**A303 Amesbury to Berwick Down  
(Stonehenge) Wiltshire  
TR010025**

**Wiltshire Council (A303-AFP022)  
Written Summaries of Oral Submissions  
put at the Issue Specific Hearings held in  
August 2019**

Application Document Number	Rev
TR010025 - 2.12	P03

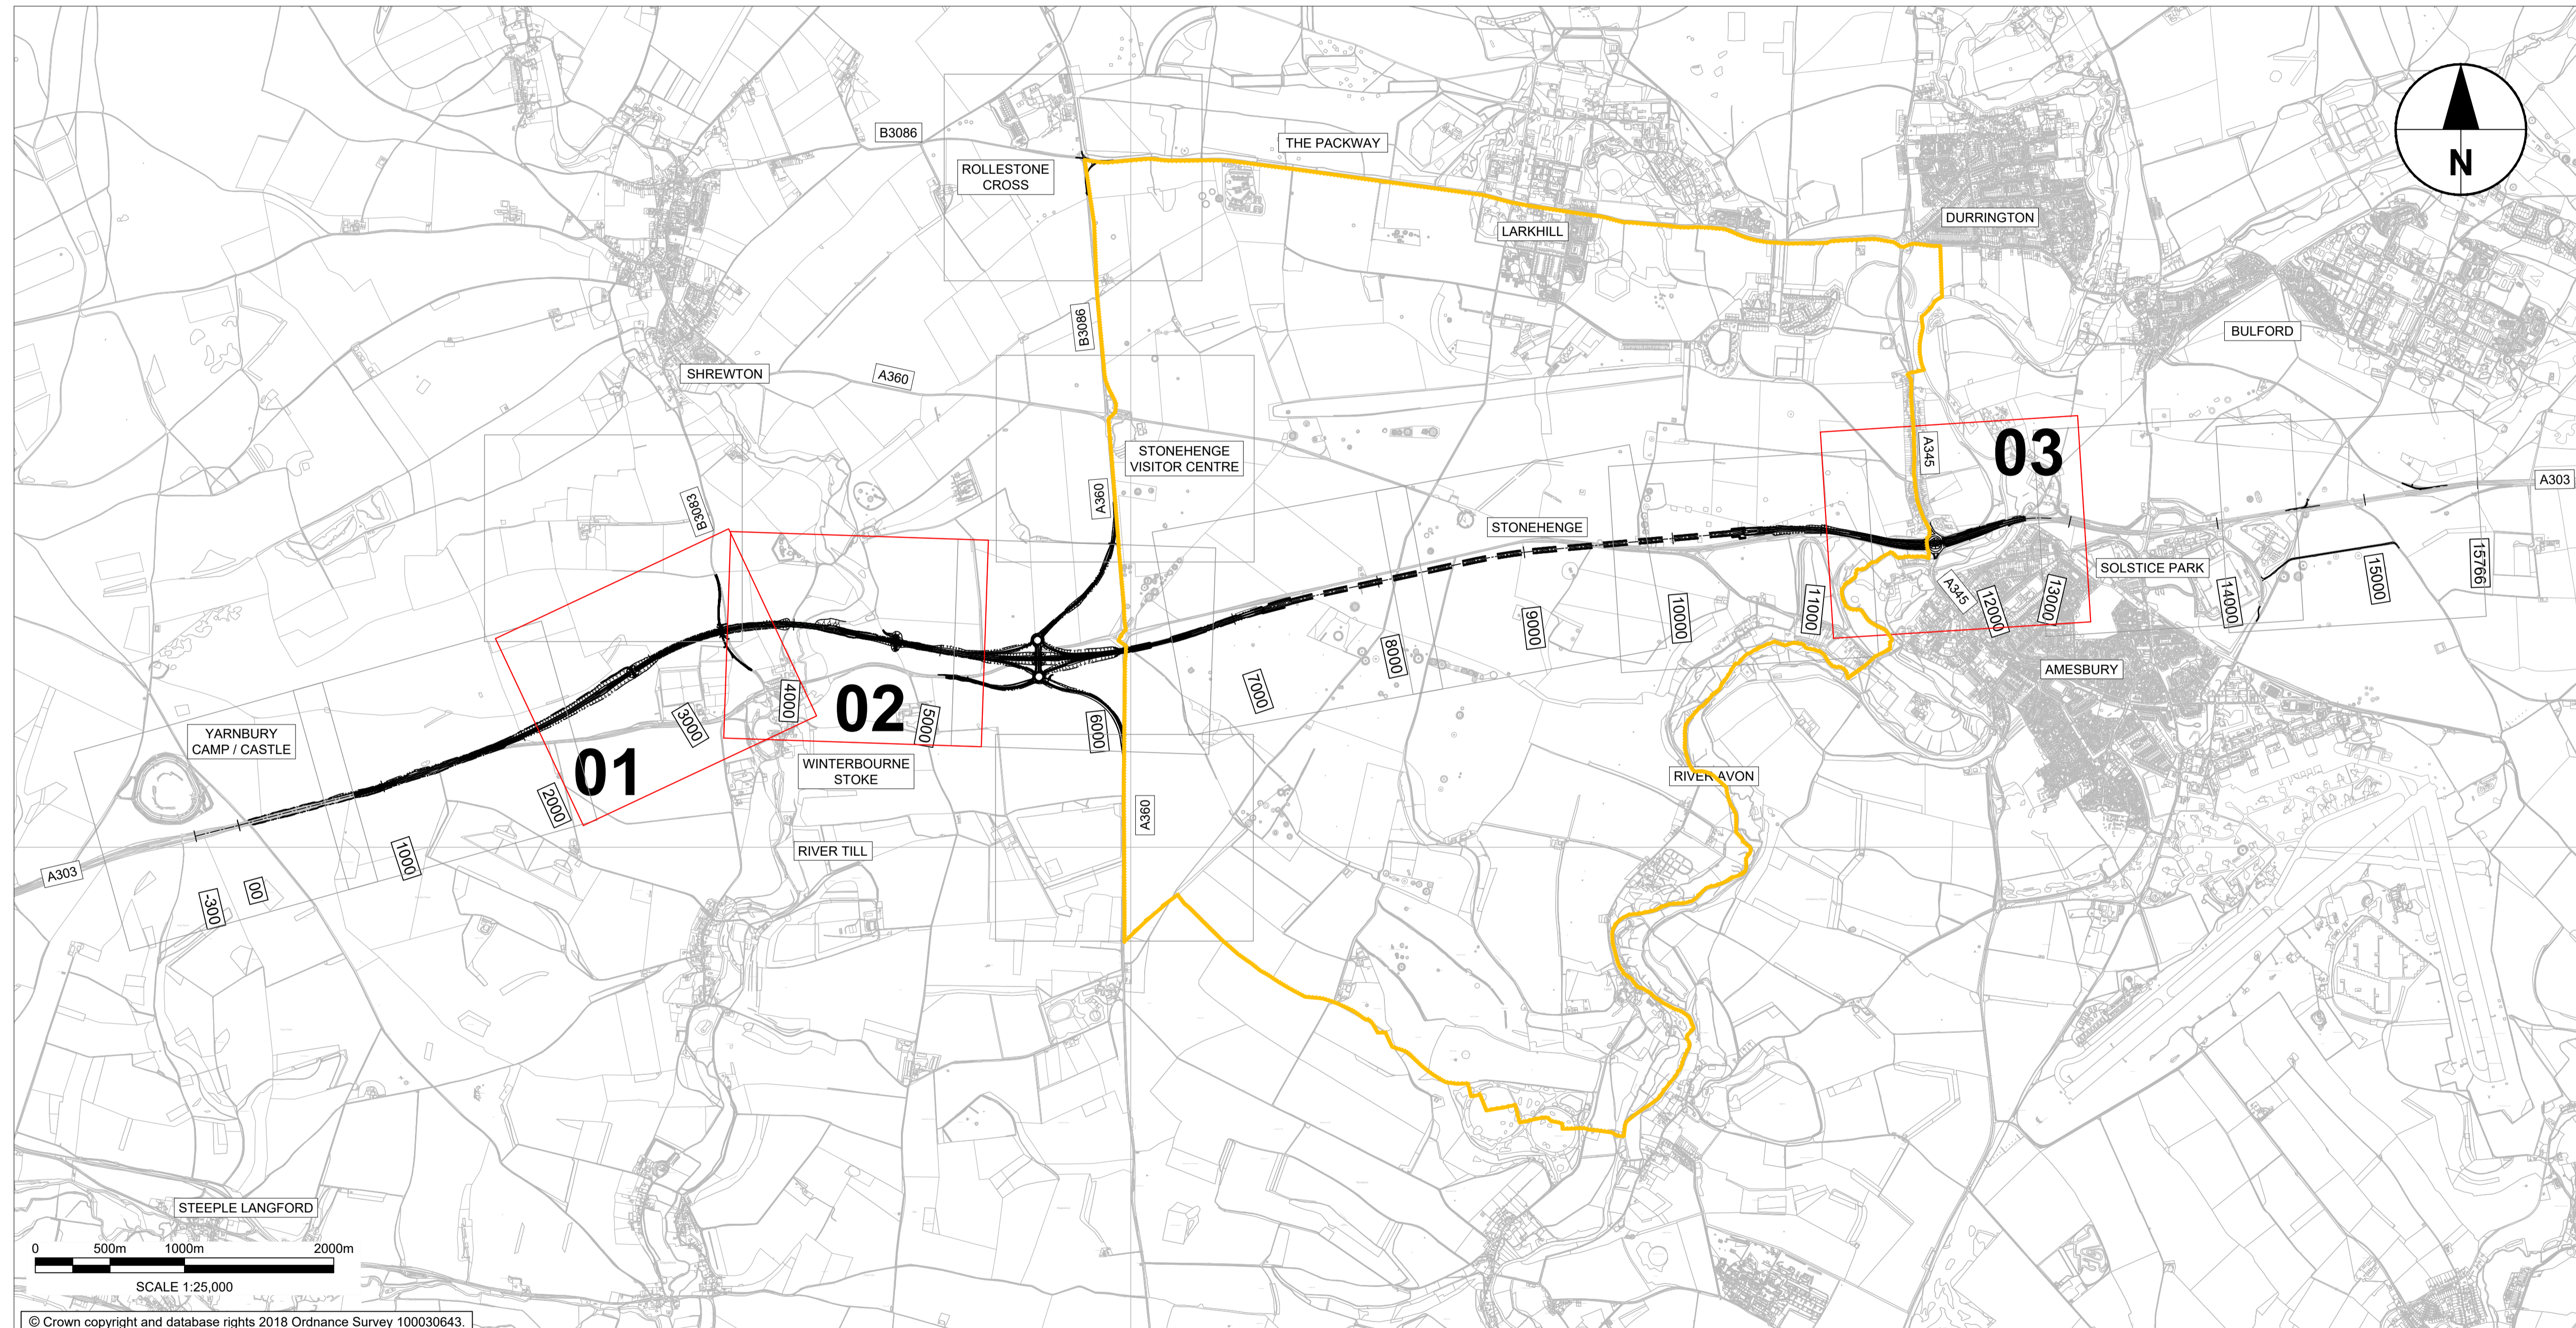
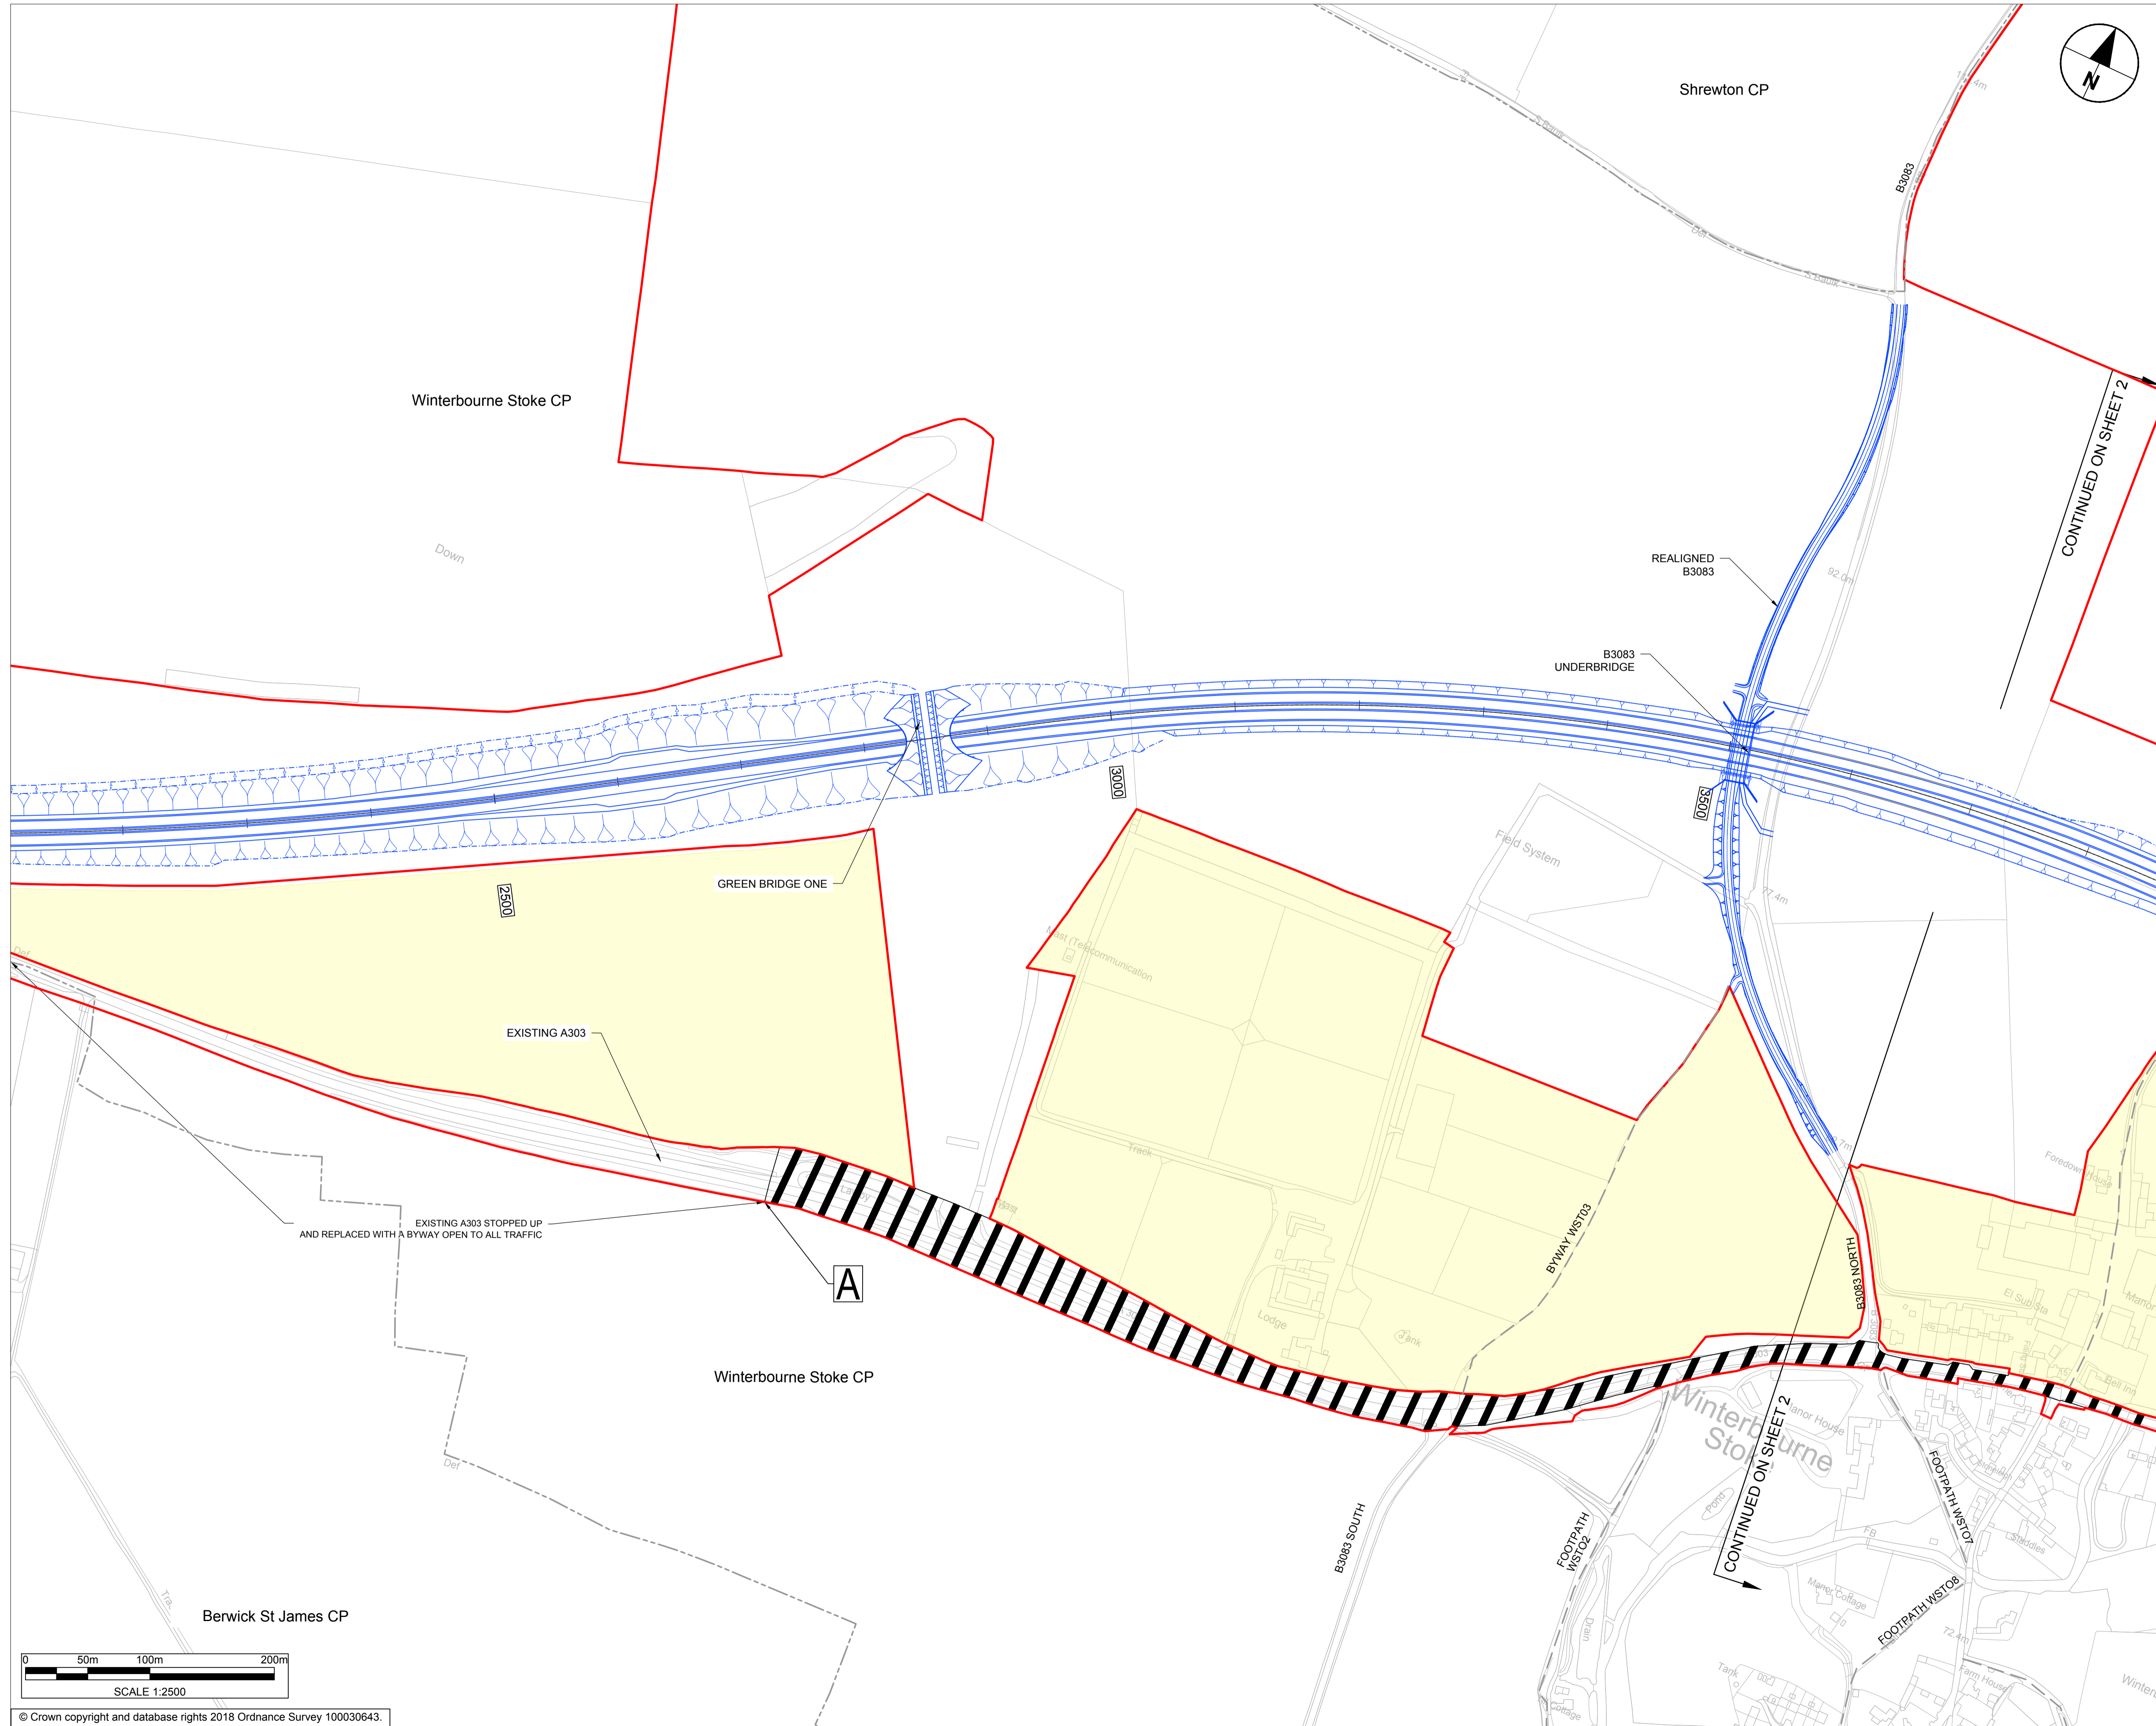
2.2.1 The Council confirmed that it supports proposed change NMC-02 in principle, however the precise boundary between the trunk road and local roads needs to be confirmed. The Council also indicated that there were points of detail on the plan legends which required resolution.

“Whilst the proposed change is in line with the general principle put forward by the Council, there is concern about the detail of the area shown hatched black, which excludes verge areas to the north and south sides of the junction, which are currently understood to be trunk road (maintained by HE, not Wiltshire Council), and which should be de-trunked to become verges to the A345 north-south route.

The highways records held by the Council show that there is significant verge area around all parts of the roundabout. The Council would wish to see the de-trunking hatch markings extend into the verge to the north side of the eastbound diverge and merge slips, and to the south of the westbound diverge and merge slip roads. The Council would be happy to agree the precise boundary between the strategic roads and the local roads with HE prior to their finalisation of the de-trunking alterations.

It is noted that the De-Trunking Plans Key Plan will need to be amended to accommodate a Sheet 03, but there is no need to show in the legend ‘Existing A303 to be de-trunked...’ because this detail will be shown on the individual drawing sheet. The change from before to after drawings for the Key Plan, removing the dashed line requires some explanation, but the Council raises no issue as to how the tunnel section of the Scheme is presented on a Key Plan.

The proposed change to the legend, as shown in the consultation document should be changed, for Sheet 03 only, to read ‘Existing A303 to be de-trunked (Area C)’ rather than the proposed ‘Existing A303 to be de-trunked (Area A to B and C)’. The rationale for this is because A to B will occur only on Sheets 01 and 02, and Area C will only be found on Sheet 03.”
